**Application 3/2021/0275**

**Location: Land behind The Dog Inn, Market Place, Longridge PR3 3RR**

**Proposal: Proposed erection of 9 new dwellings and associated works**

I refer to the recent letter from United Utilities dated 18<sup>th</sup> August 2021 in which further additional information has been requested to be submitted in support of the application.

Planning Application  
Proposed Site Plan

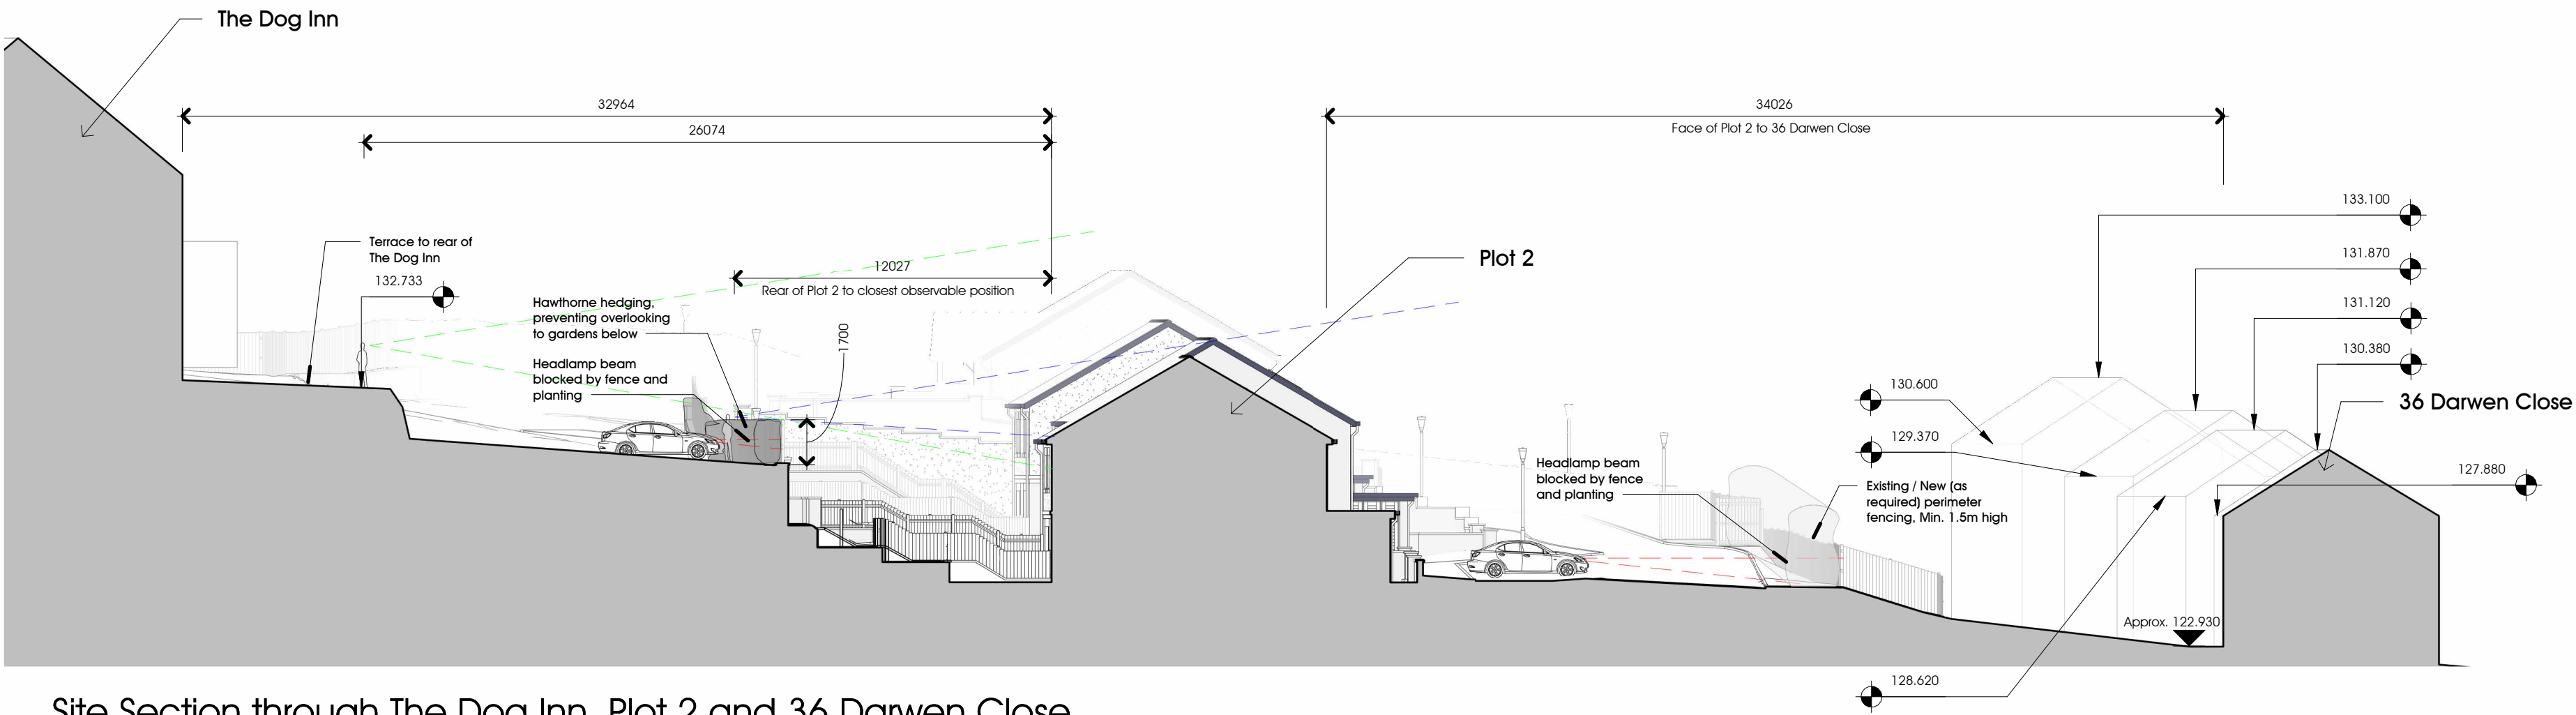
1. We welcome the indication of the proposed point of connection for foul water. However, the cover level details of the proposed connection point for foul water, and the full detail of finished floor and ground levels for all the plots, remains outstanding. From the information submitted to date, it is not possible to clearly ascertain the finished floor levels and proposed ground levels.

2. Previously we noted that with regards to the proposed ground levels, the submitted site sections indicate a reduction in ground levels around various plots such that the buildings will be significantly lower than surrounding land and the cover levels on the existing sewer that passes through the site. We therefore continue to request that the applicant confirms finished floor and ground levels and the overland flow and exceedance paths from surface water and in the event that the retained element of the sewer surcharges from existing / proposed drainage systems. It will be important that the final topography of the site guides the flows from any surcharged manhole away from the proposed dwellings and their associated curtilages where possible.

Response: We attach to this letter the proposed site layout that shows plot finished floor levels and ground levels. The proposed cover level of the proposed connection point for foul water is shown on the attached marked up copy of the proposed drainage layout and is at a level of 124.40m AOD.

Response: Finished floor levels and ground levels are shown on the plan attached to this letter. Exceedance flow routes from the public sewer crossing the site will be either along the proposed access road or along the existing footpath to the west of the development as shown on the attached marked up copy of the proposed drainage layout. The surface water drainage system serving the proposed dwellings has been designed to cater for the 100 year plus 40% added for climate change event. Any exceedance flow from this system will be from the soakaway, which has been located at the lowest point of the site, and will not affect the proposed dwellings.

Section along existing drain

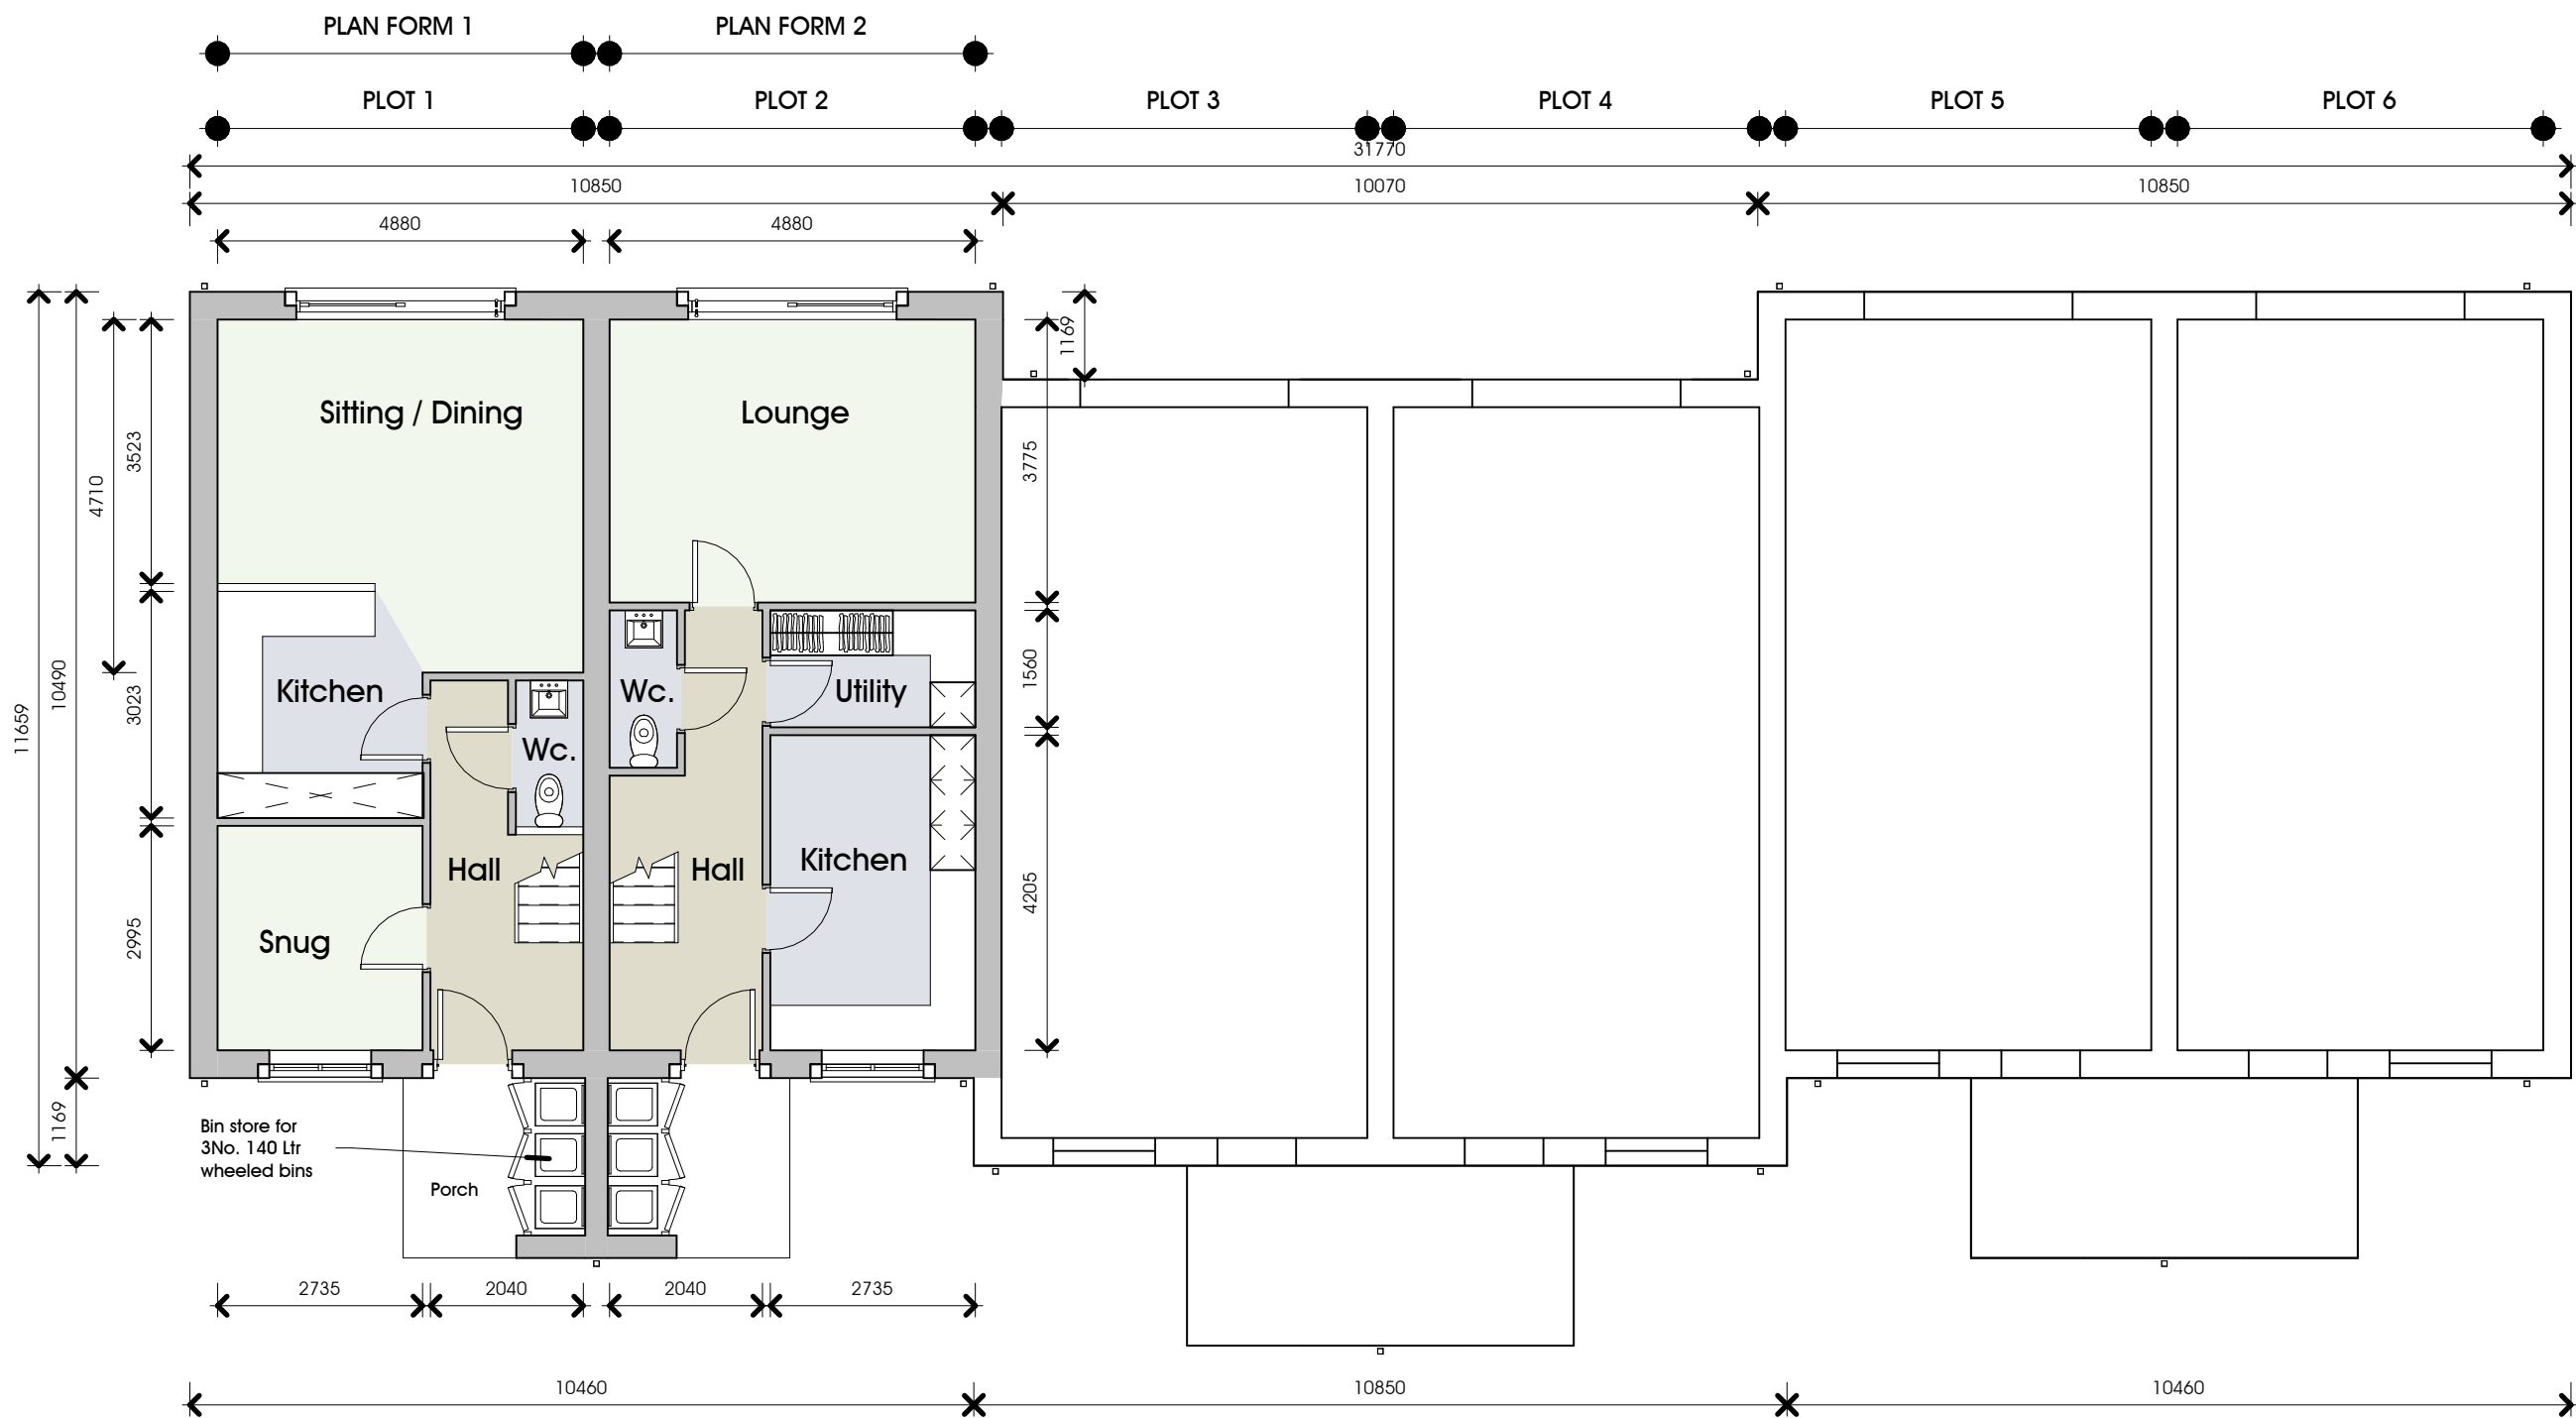
4. In our previous correspondence we noted our review of the submitted cross section in relation to the sewer and expressed our concerns at the proposed approach. Noting our concerns regarding the absence of evidence to confirm connectivity to the retained elements of this sewer and the absence of a cross section relating to elements of the sewer that the applicant proposes to retain as public; our previous concerns have not been fully addressed. We previously noted that the cover on top of the existing sewer that passes through the site is proposed to be reduced to as little as 0.482m. This is not acceptable to United Utilities and needs further consideration with our Developer Engineer. We also expressed our concern that the proposed retaining wall arrangement

within the rear gardens will compromise access to the public sewer for maintenance, repair or replacement. In conclusion, further discussions will be necessary with our Developer Engineer to fully understand what elements of the sewer need to be diverted to facilitate this scheme after obtaining a full understanding of any change in levels and connectivity. This will need to be addressed as part of a sewer diversion under s185 of the Water Industry Act 1991. Any diversion of the public sewer will be at the applicant's cost.

Response: We attach a plan showing the section along the line of the current public sewer that lies between the public house and the proposed dwellings that is intended to become a private drain. The invert levels shown are accurate. From the section it can be seen that the minimum cover to the pipe is 0.844m.
